Bolton by Bowland, Gisburn Forest & Sawley Parish Council
Higher Scarloom House,
Holden, Bolton by Bowland
Clitheroe
BB7 4PF

14 March 2023

Subject: Re: Holden Clough Nursery Planning Application 3/2022/0052

Please be advised that Bolton by Bowland, Gisburn Forest and Sawley Parish Council wishes to object to the above application.

Drawing file: planx_downloads / 22_0052_Proposed_Cafe_Plan_Rev_Ga_17Feb23.pdf

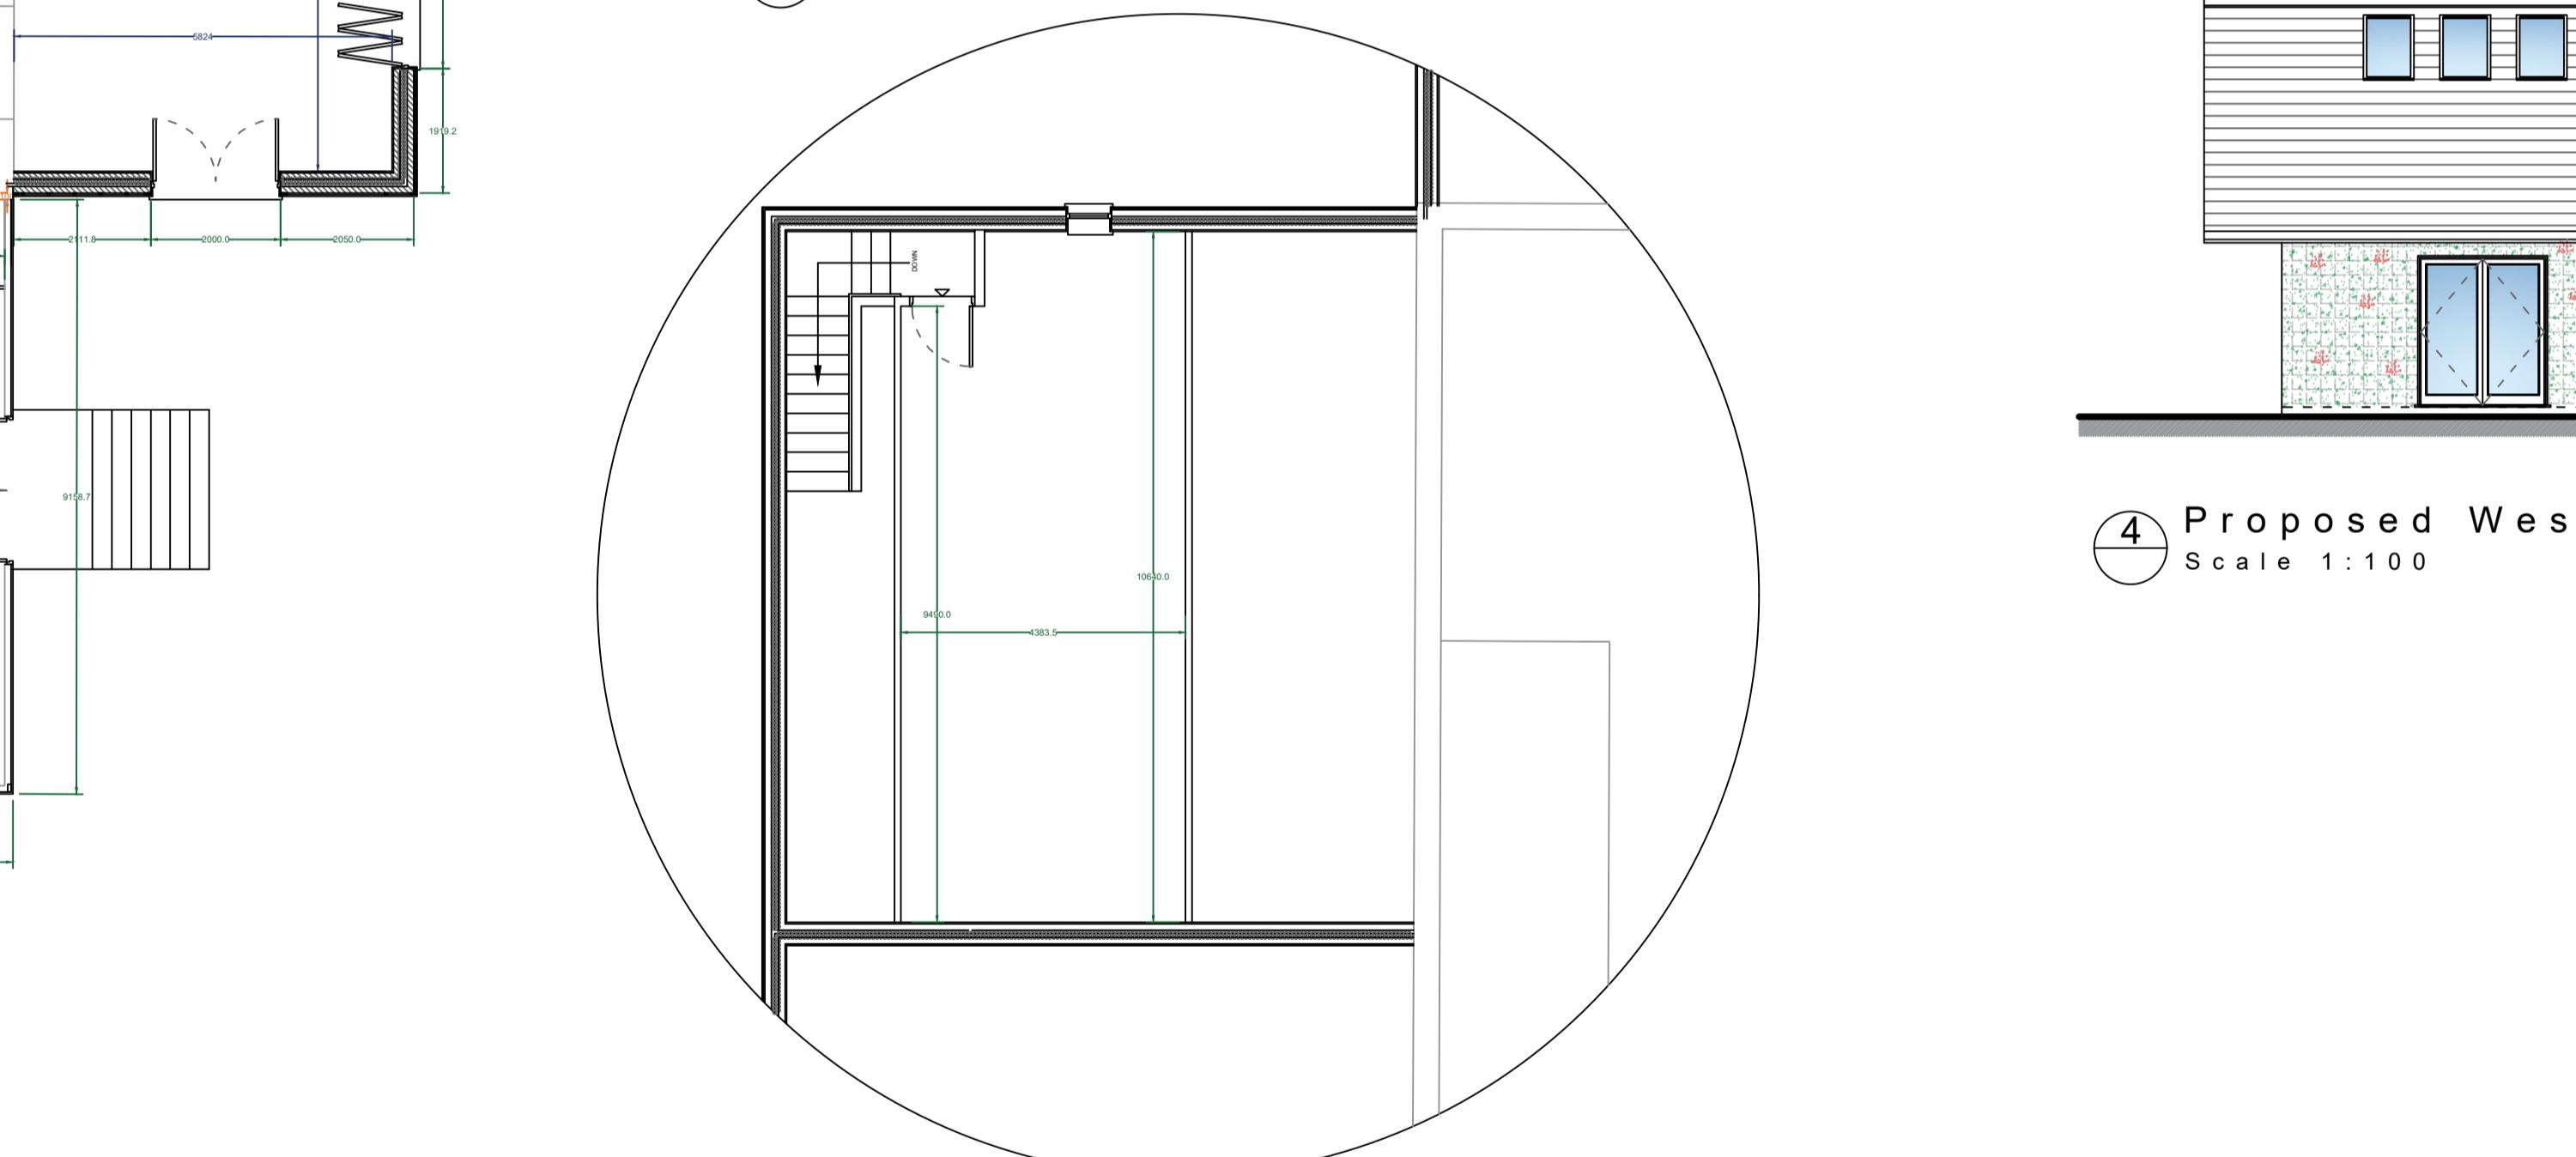
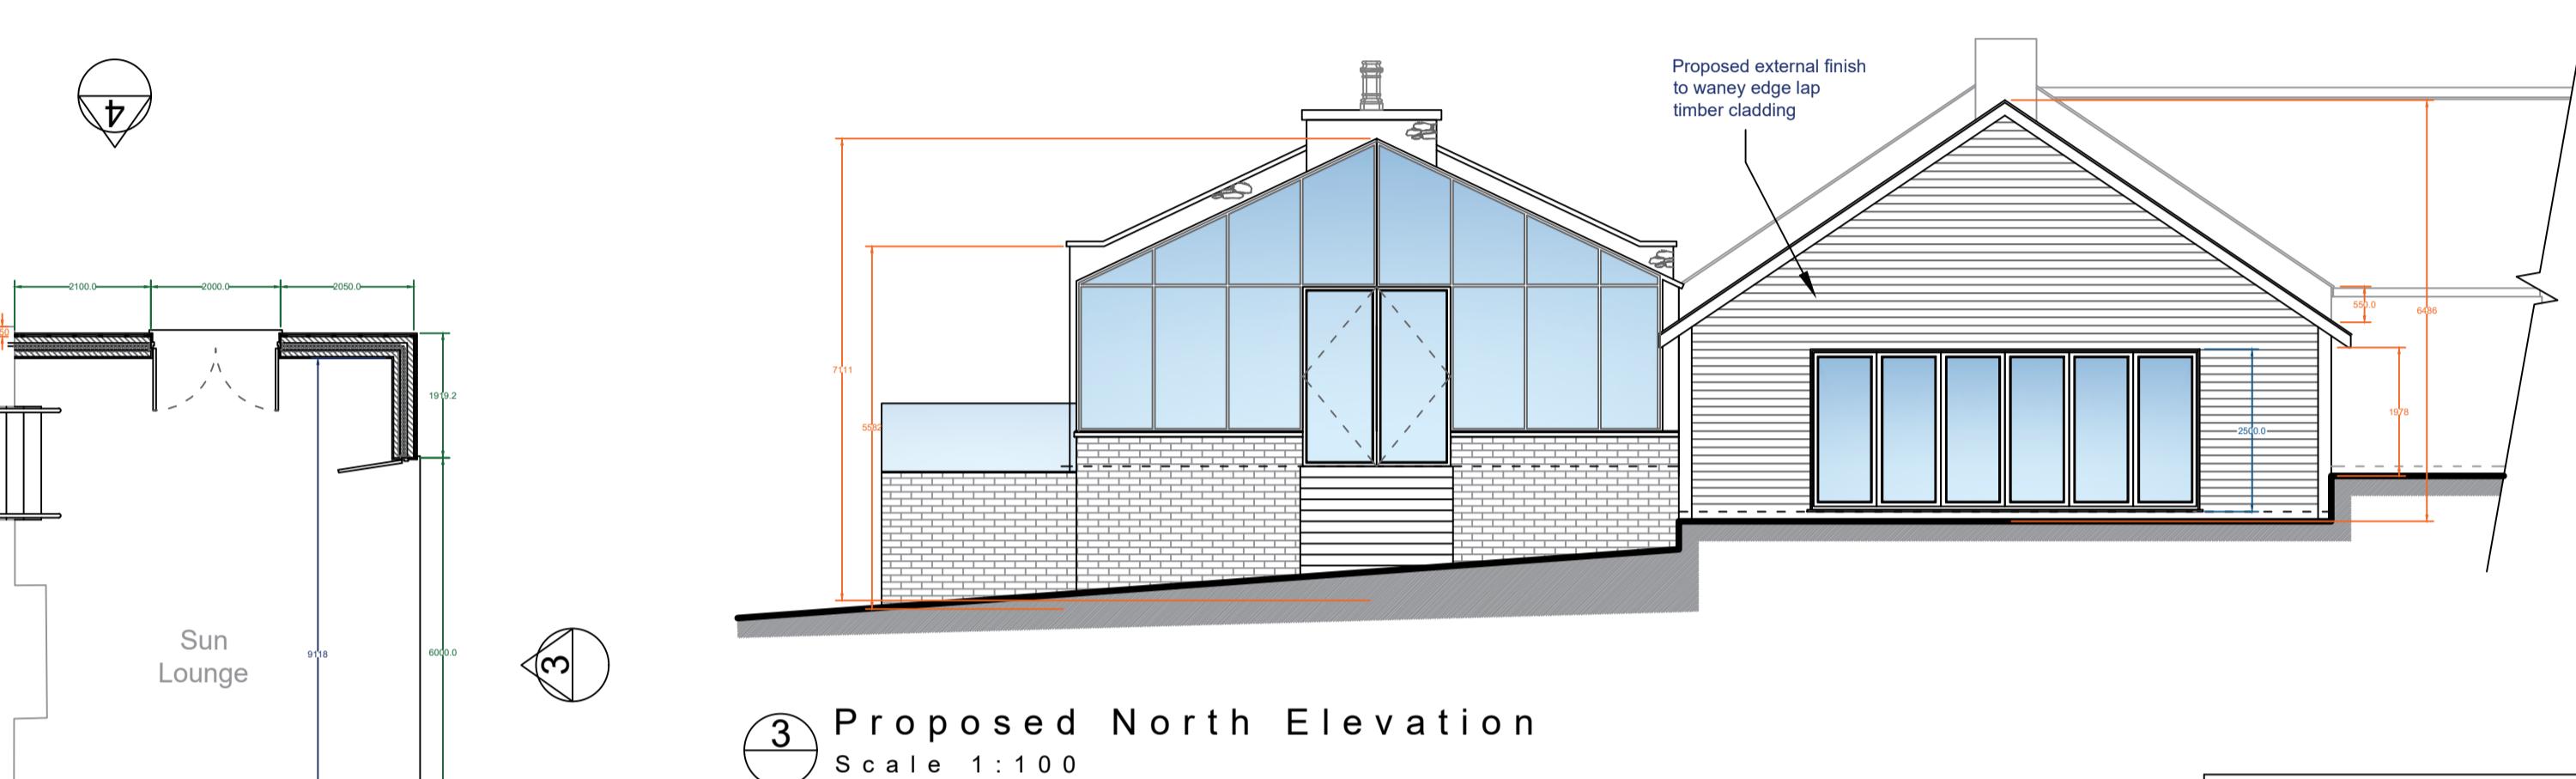
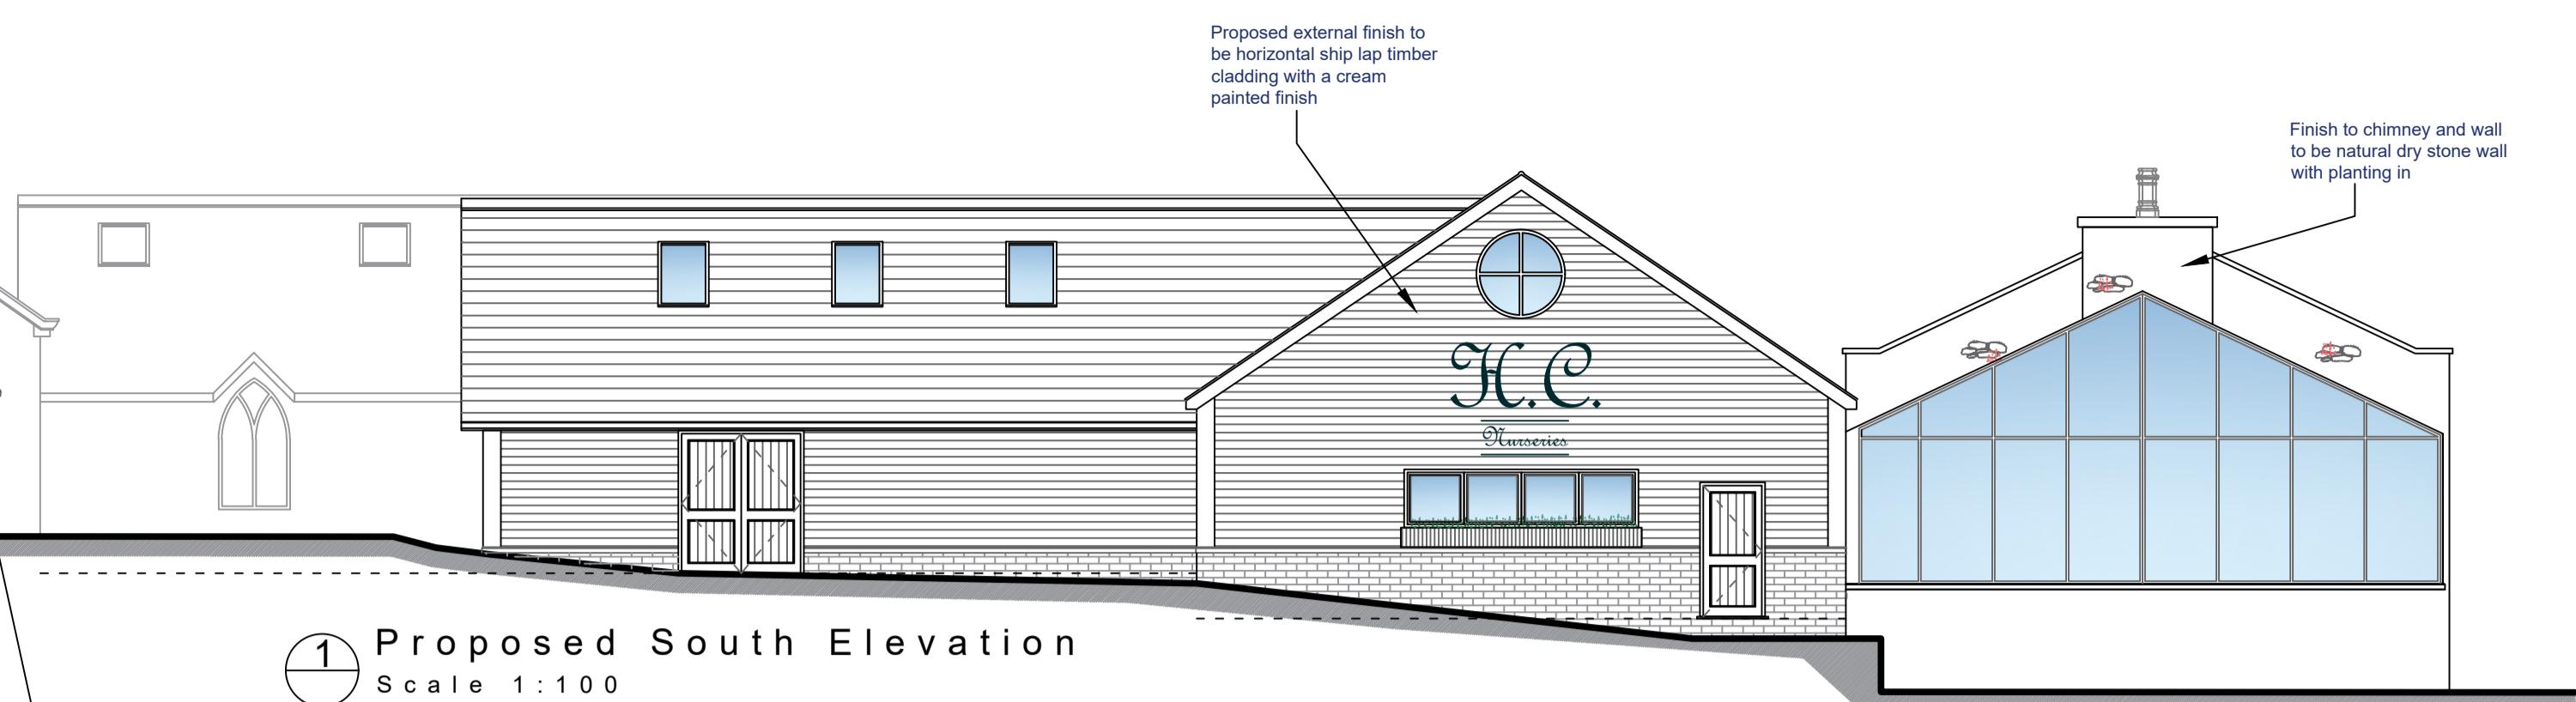
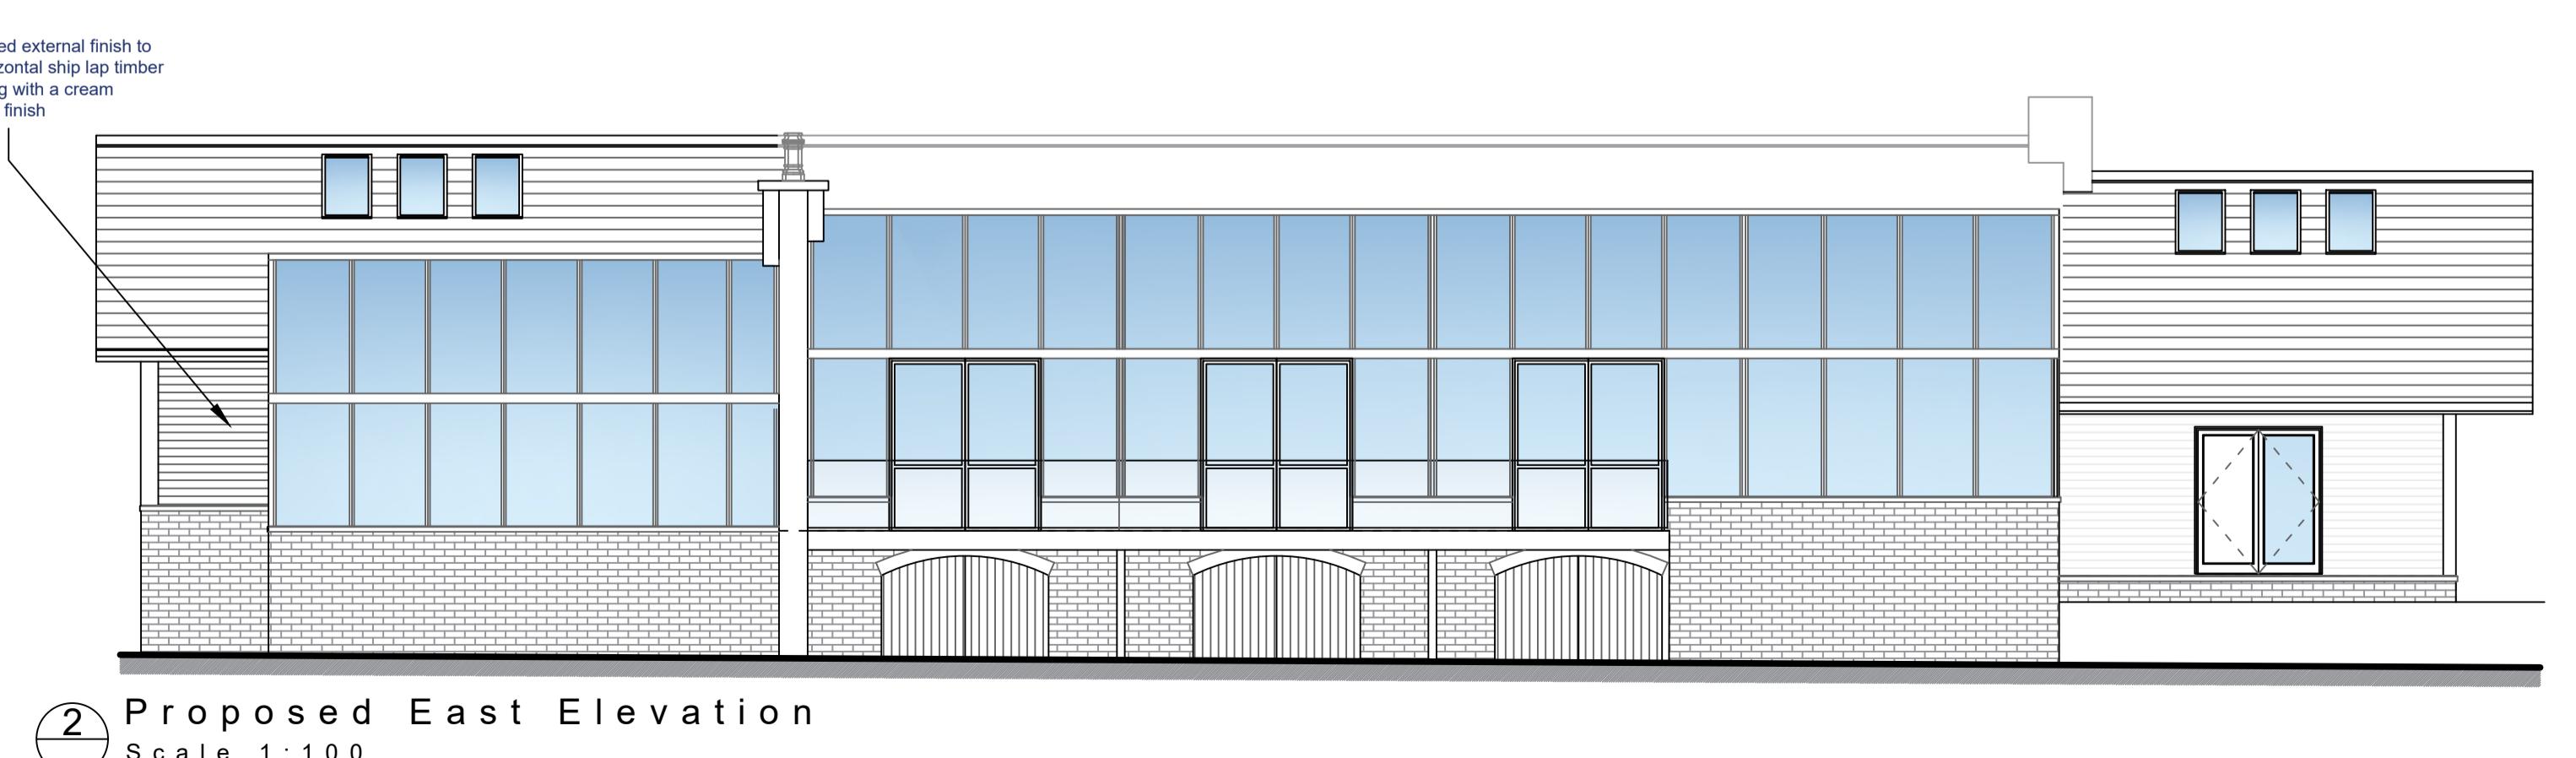
In the previously submitted application (3/2020/0602), the increase to the internal floor space was stated as being 354sq.m. And, in this resubmitted application (3/2022/0052), the internal floor space has reduced slightly to 345sq.m. Both approximate to a staggering increase of 80% of internal floor space. The applicant states that the proposal is "a relatively small extension" and has no intention of increasing the number of restaurants covers, which, quite honestly, does not make business sense.

In this application the Nursery is applying for retrospective planning permission for the structure built on at the rear of the original café. This didn't have planning permission and, although it was pointed out to LPA at the time it was being built, it was allowed to remain. In the new application, the Nursery is applying for retrospective approval of this

structure and permission to build a new structure along the eastern and southern sides of the Kitchen Garden.

Parish Council - The development will have a significant visual impact from both the Eastern and Northern sides of the existing site.

Parish Council - The terrace and Glasshouse extension will adversely impact upon neighbour amenity both in terms of visual impact, visitor intrusion and the noise levels form the open terrace to both the East and Northern boundaries of the site. This is contrary to Natural England’s “natural beauty criteria ”. The consistent flouting of previous permissions and environmental regulations should be considered by RVBC.
